Please ask for: Ms Iqraa Malik
Email: iqraa.malik@terraquest.co.uk
Telephone: 0121 234 1390
Our Ref: AB/62/22/L
Your Ref:
Date: 17th May 2022

Listed Building Consent for Alterations, Extension or Demolition of a Listed Building

Development: Conversion of loft to habitable use including installation of 3 x dormers and rear juliette balcony, addition of rendering, and alterations to fenestration/openings. This application may affect the character and appearance of the Arundel Conservation Area and affects the setting of a listed building.

Location: Mews House London Road Arundel BN18 9BH

Location Plan for 3958 - Gray

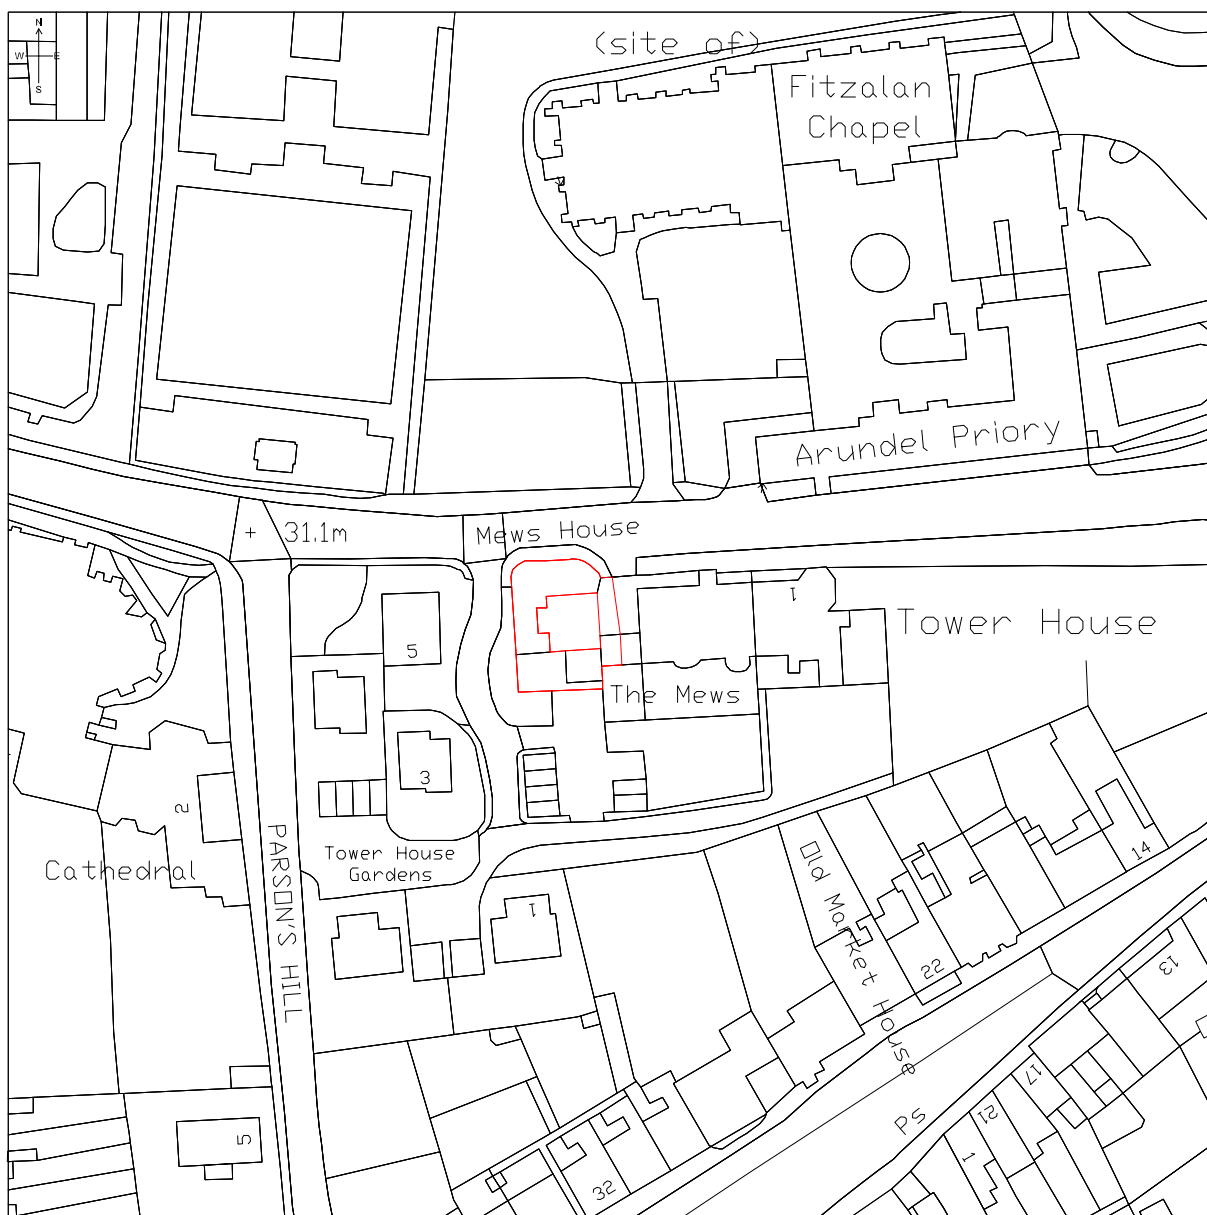
Location Plan

The location plan does not measure to scale. Please review and amend.

Site Plan / Block Plan for 3958 - Gray

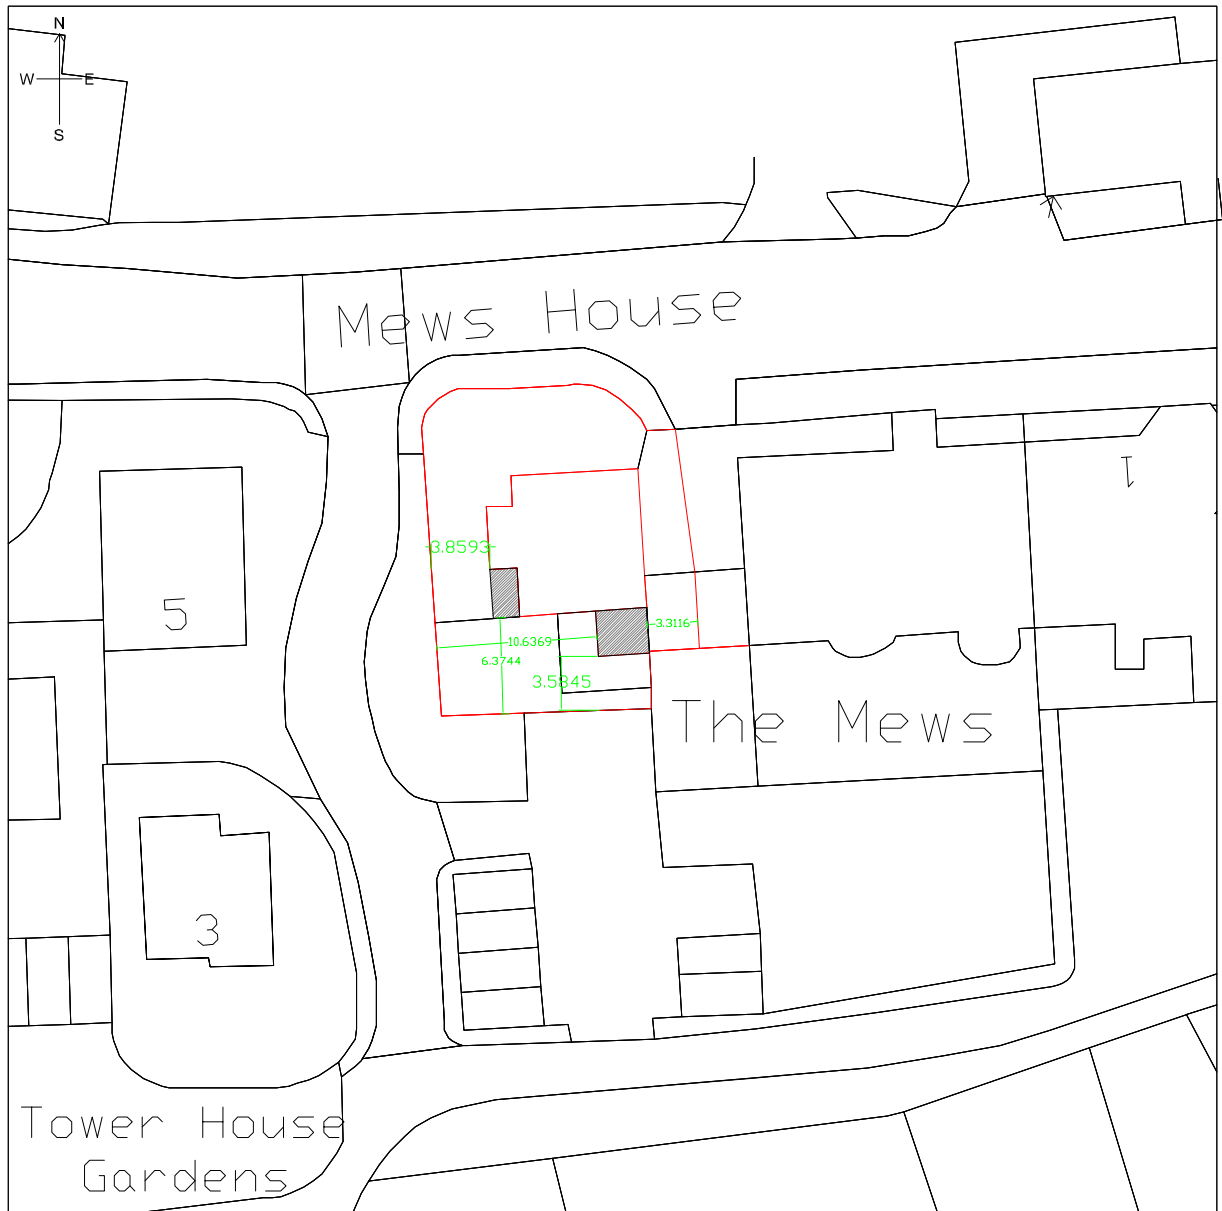
Block Plan

The block plan does not measure to scale. Please review and amend.
